**TOWER 2, LEVEL 23
DARLING PARK, 201 SUSSEX ST
SYDNEY NSW 2000**

SECTION 4.55(2) MODIFICATION 2 TO SSD 7037 | 75-85 HARRINGTON STREET, THE ROCKS | RESPONSE TO SUBMISSIONS

project code GA85H sheet no. DA-2009 revision A6

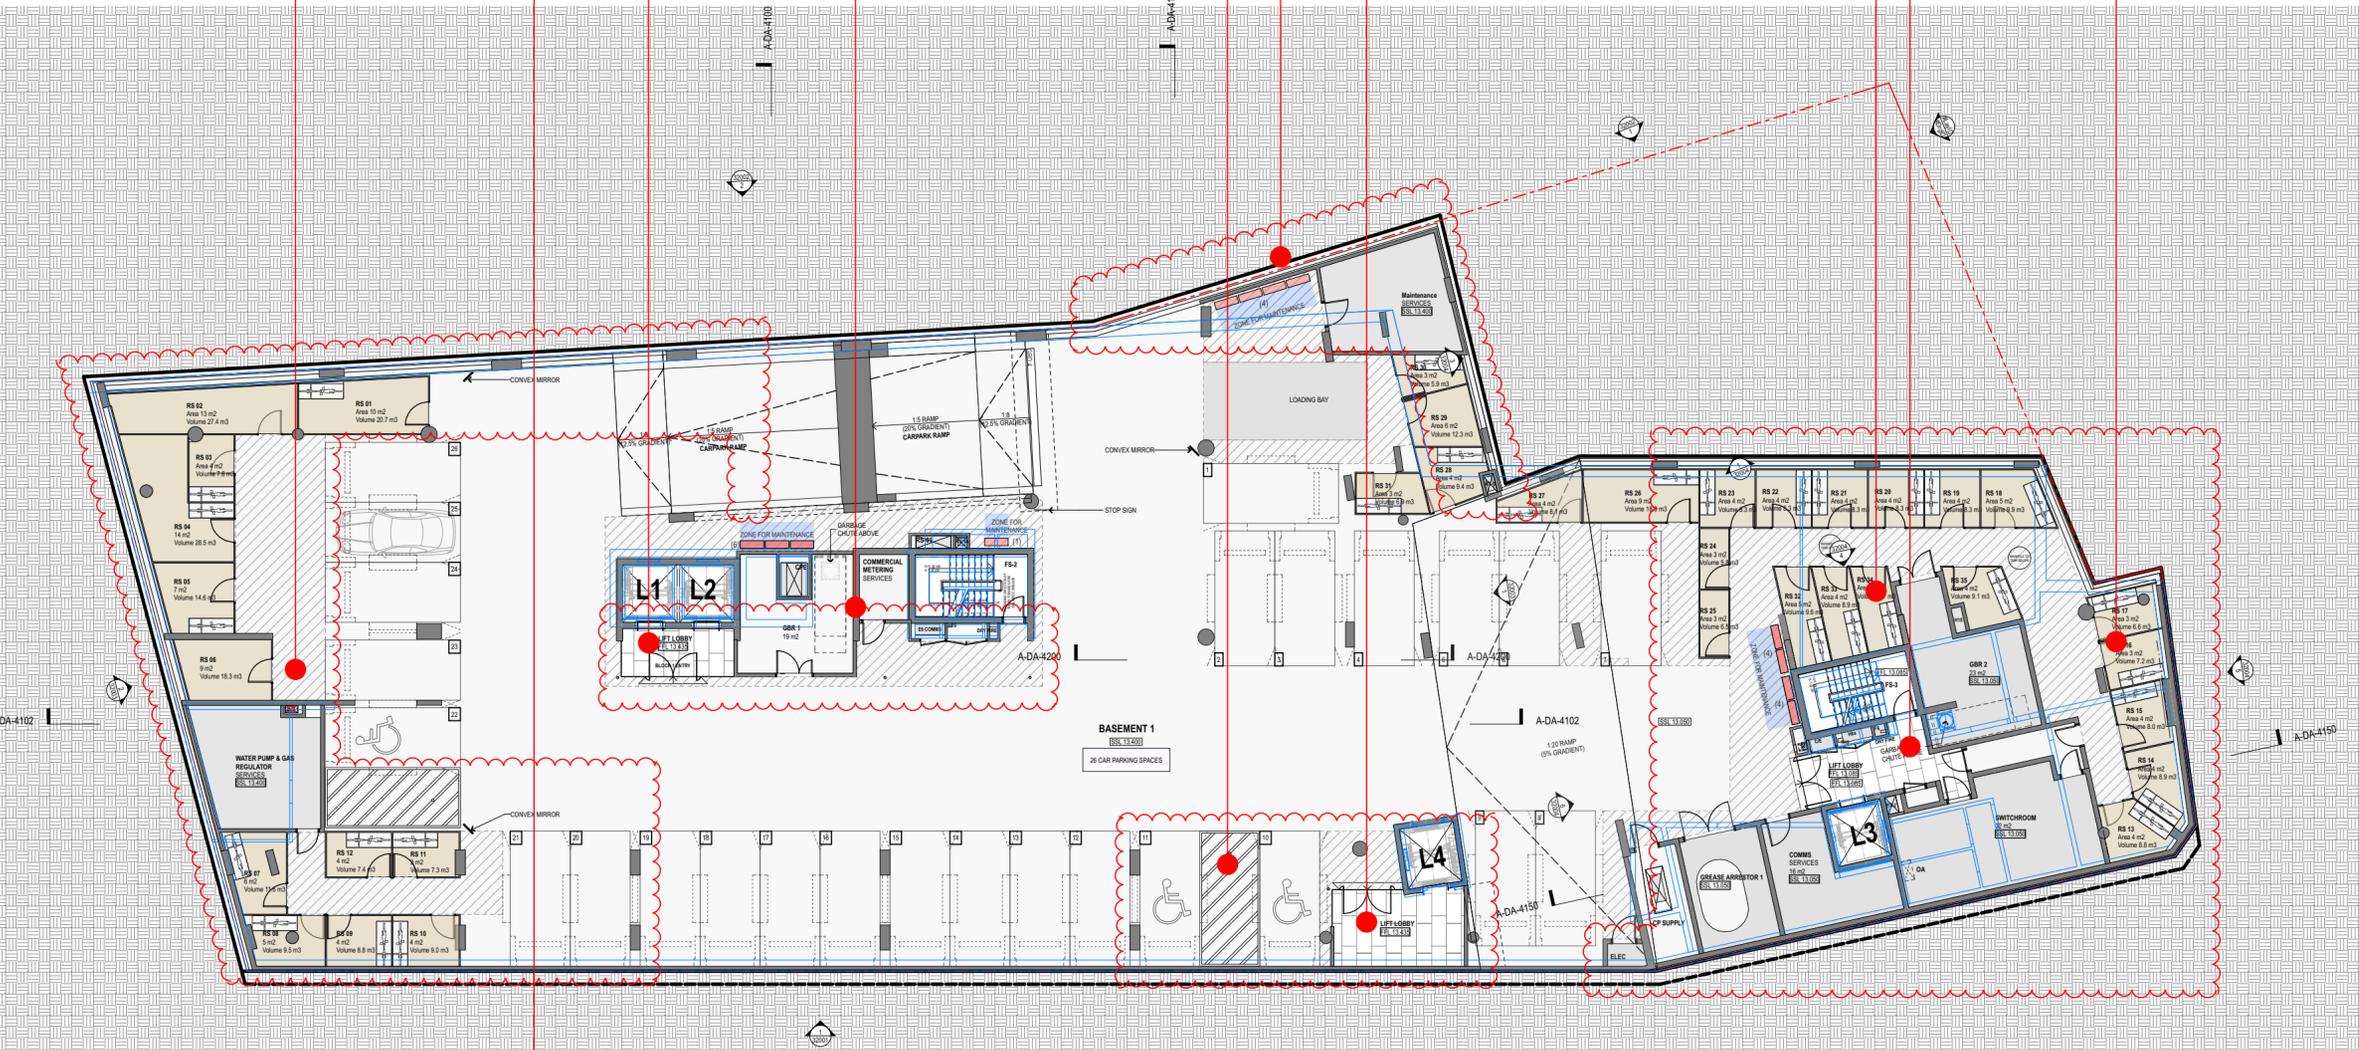
One further (minor) internal planning amendment has been made to Block 1, Level H9 as a result of interior design development. This change does not significantly alter the quantum of communal area and will improve the amenity of this space.

project code GA85H sheet no. DA-2012 revision A6

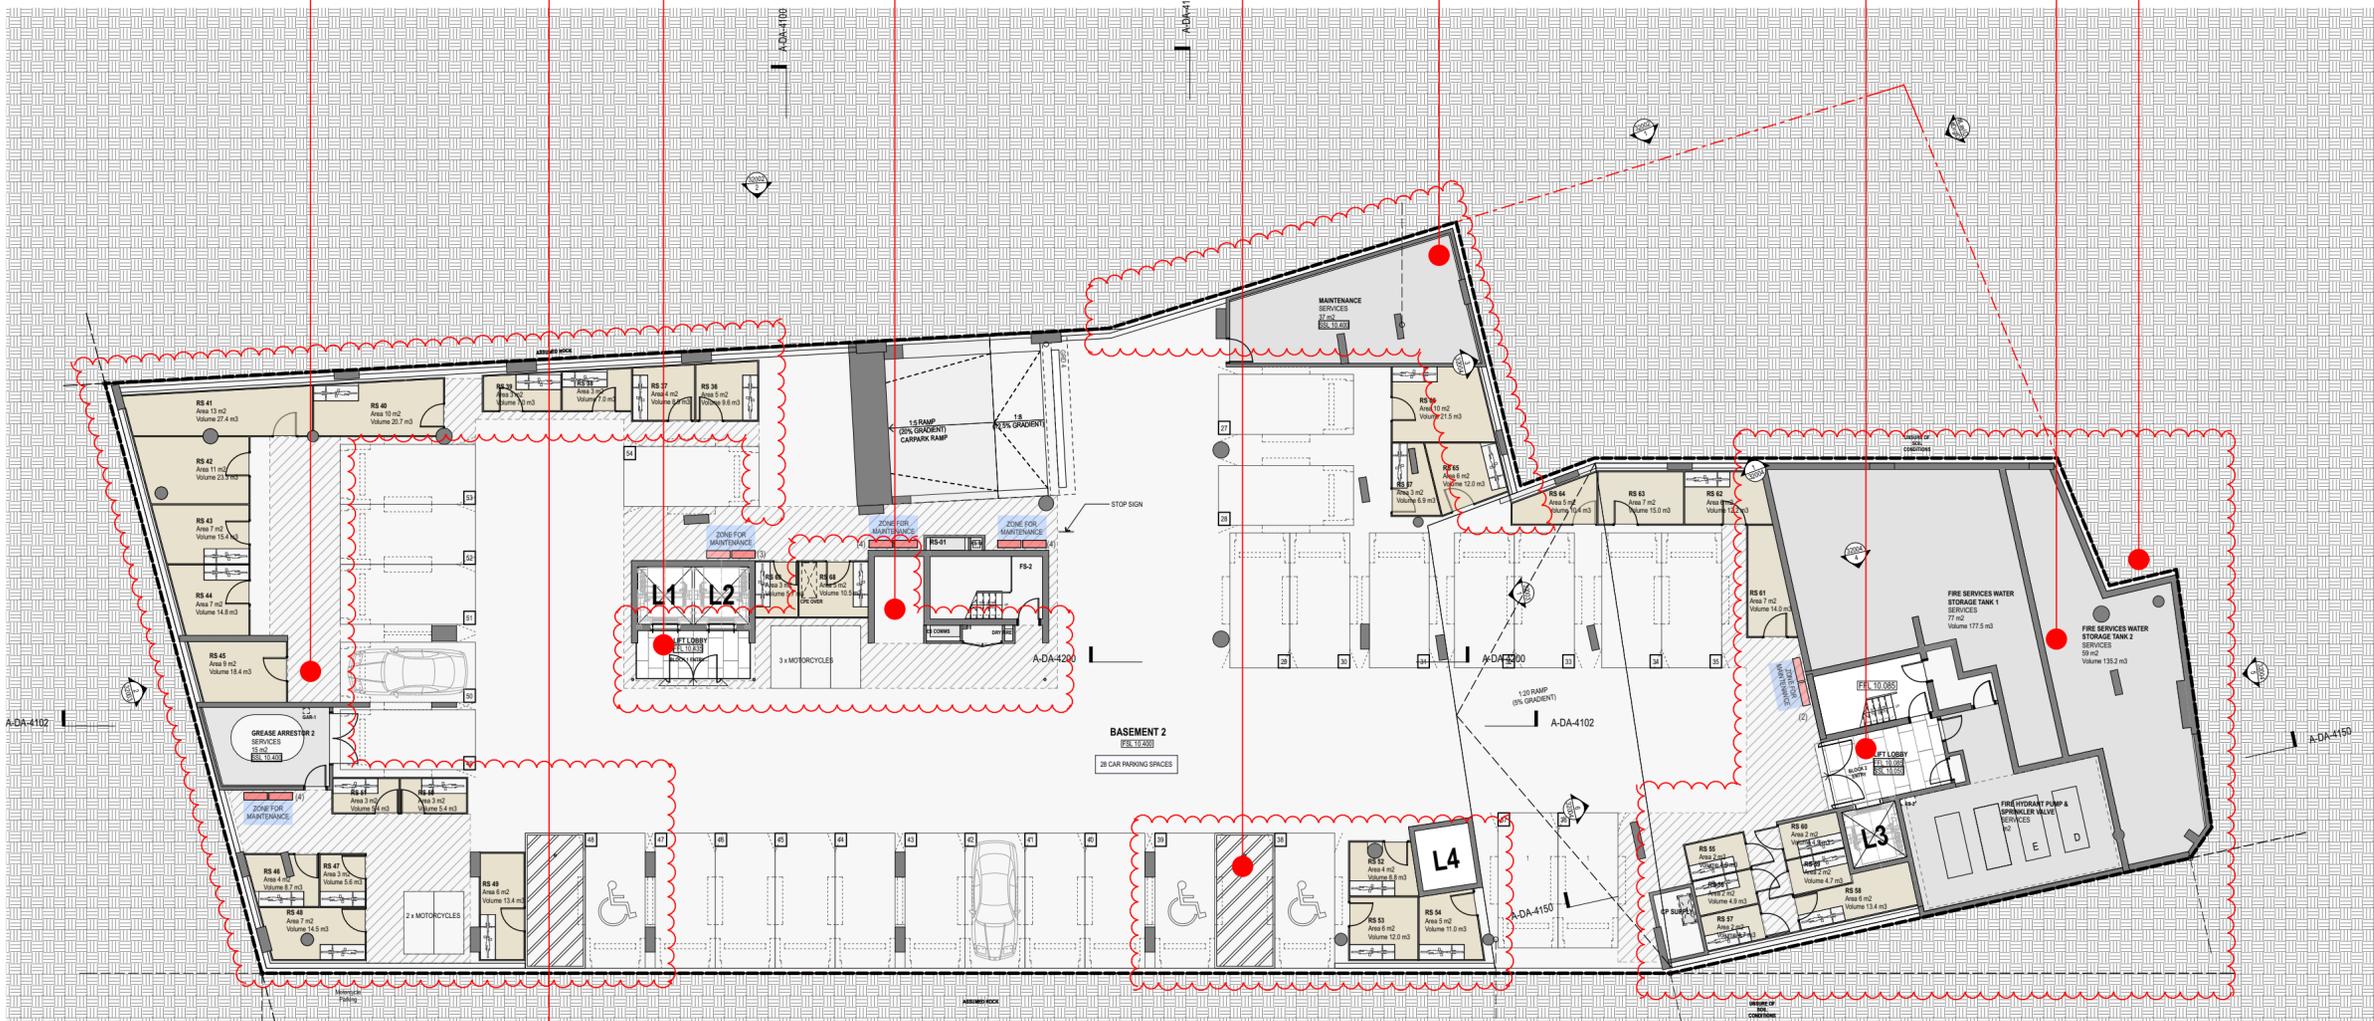
Issue	Response	Reference
Design		
<ul style="list-style-type: none"> Give consideration to the proposed inclusion of additional louvres to the roof. 	<p>FJMT have prepared three perspectives (see Appendix D) which illustrate how the louvres will appear from key spaces within the public domain. In summary:</p> <ul style="list-style-type: none"> The roof and louvre material will be metal sheeting of the same colour, meaning the architectural language of the building will remain the same. This is also supported on Heritage grounds (refer to HIS). Notwithstanding this, the amendment to the roof will be barely perceptible from most viewing angles (refer to the perspectives). 	Appendix D
Bicycle Parking		
<ul style="list-style-type: none"> Fifty-eight bicycle parking spaces should be provided unless sound justification is given for a proposed reduction. 	The basement drawings have been amended. Each of the 58 apartments will receive at least one basement storage cage (inclusive of a bike store).	Drawing DA-2011 and DA-2012 at Appendix B

project code GA85H sheet no. DA-2800 revision A7

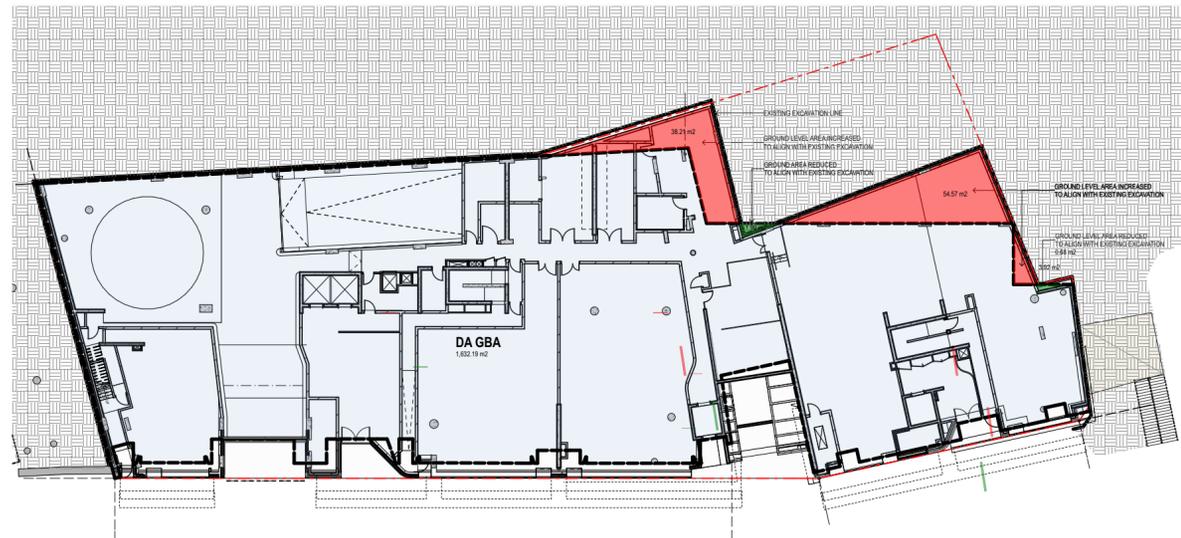
Issue	Response	Reference
Heritage		
<ul style="list-style-type: none"> Update the Heritage Impact Statement to reflect the latest drawings (Revision 6) and the comments received from the Heritage Division of the Office of Environment and Heritage. 	<p>An Addendum Heritage Impact Statement (HIS) has been prepared which includes the latest drawing revisions. The Heritage Package (Appendix A) has also addressed each of the OEH comments in a cover letter.</p>	<p>Appendix A</p>
<ul style="list-style-type: none"> Confirm all basement walls assigned a significance of high or exceptional are proposed to be retained as per Condition B2. 	<p>The Addendum Heritage Impact Statement confirms that all basement walls assigned a significance of high or exceptional will be retained.</p>	<p>Appendix A</p>
Gross Floor Area		
<ul style="list-style-type: none"> Provide an updated schedule of Gross Floor Area for all uses, justification for proposed amendments and an assessment of implications. 	<p>FJMT have prepared a revision to (approved) drawing DA-2800. The drawing confirms the GFA of the building has been reduced by 30 sqm (from 9,308 sqm to 9,278 sqm).</p> <p>The decrease has occurred due to the design development of the building (i.e. confirming the size and location of services; thickness of exterior walls et cetera).</p> <p>For reference, the revised scheme has the following amounts of GFA:</p> <ul style="list-style-type: none"> Commercial: 1,134 sqm (+ 2 sqm) Retail: 948 sqm (+ 21 sqm) Residential: 7,196 sqm (– 53 sqm) 	<p>Drawing DA-2800 at Appendix B</p>

scale	As Noted @ A2	first issued	25/05/2018
project code	sheet no.	revision	
GA85H	DA-2801	01

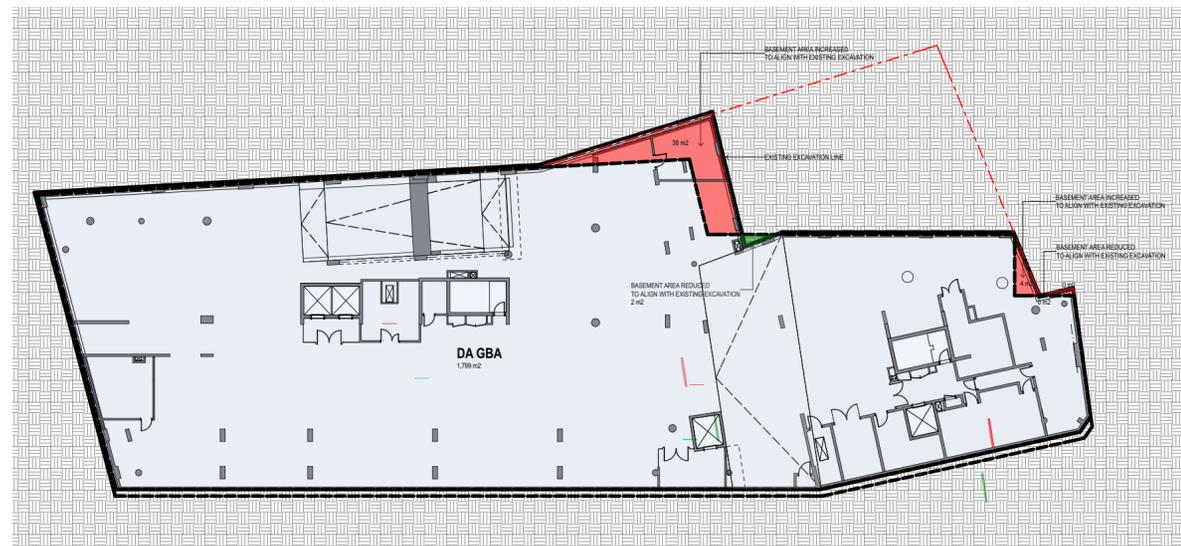
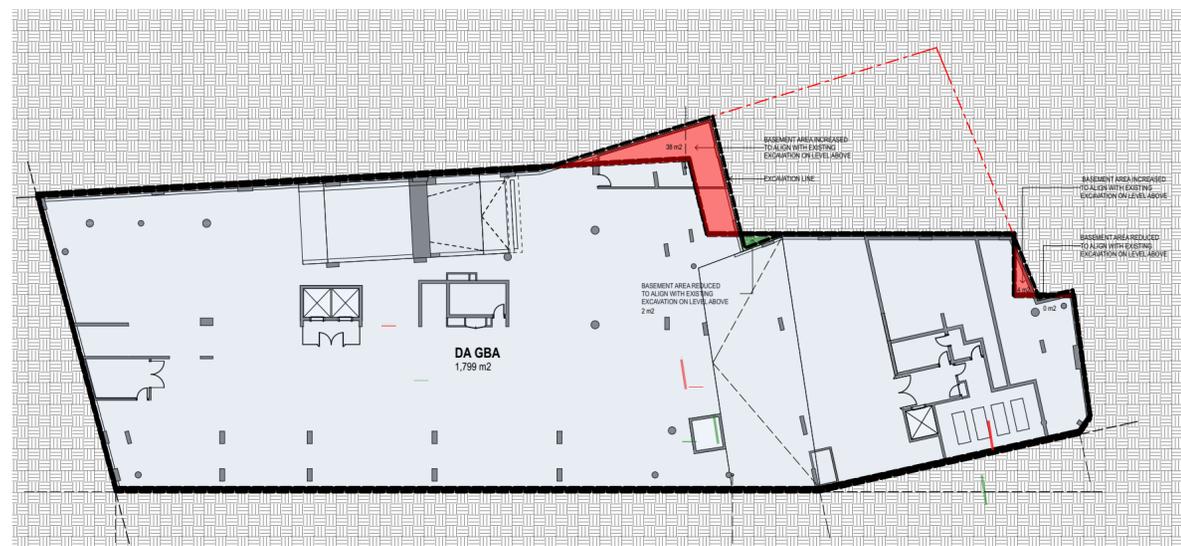
Basement and Ground Floor Alterations		
<ul style="list-style-type: none"> Provide clarification as to the extent of the amendment to the basement and ground floor outlines and justification for this. This should include an assessment of any potential impacts, including any necessary amendments to technical studies. 	<p>FJMT have prepared an Excavation Alteration Plan (drawing DA-2801). The drawing confirms there is no additional excavation beyond the existing excavated footprint.</p> <p>No further technical studies are required.</p>	Drawing DA-2801 at Appendix B

project code GA85H sheet no. DA-3005 revision A6

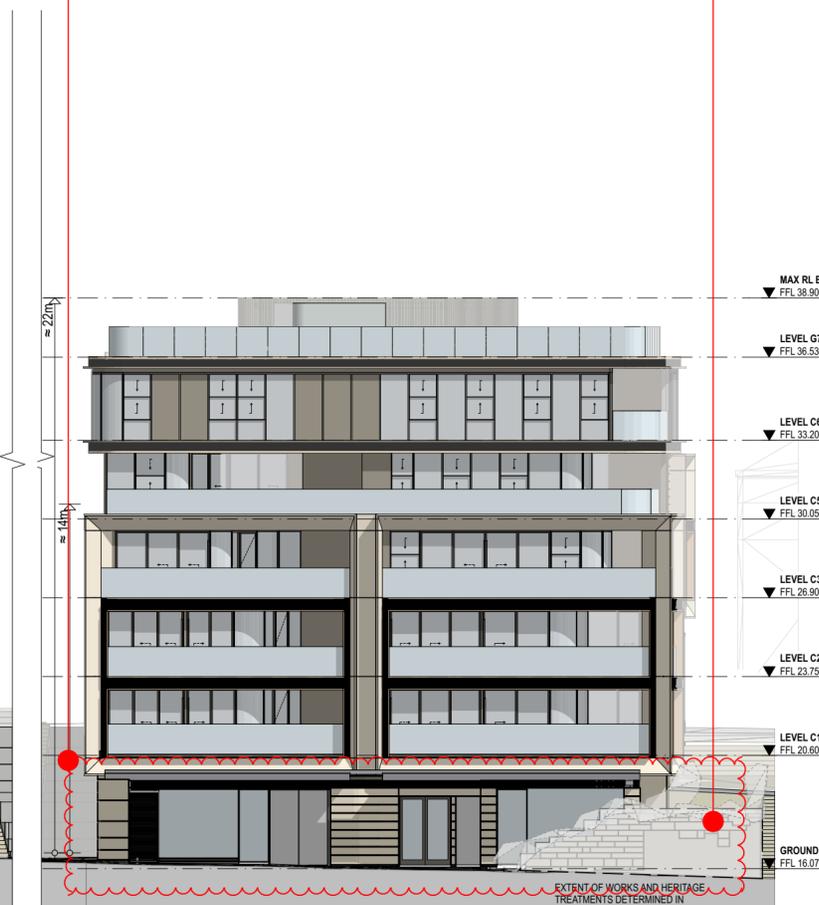
Architectural Drawings		
<ul style="list-style-type: none"> Ensure all proposed changes are shown clouded on the drawings. 	Noted.	-
<ul style="list-style-type: none"> Update the inner elevation drawings to reflect balcony changes and any other amendments 	Inner elevations have been included in the revised plan set for consistency.	Drawing DA-3005, DA-3006, DA-3007 and DA-3008 at Appendix B.
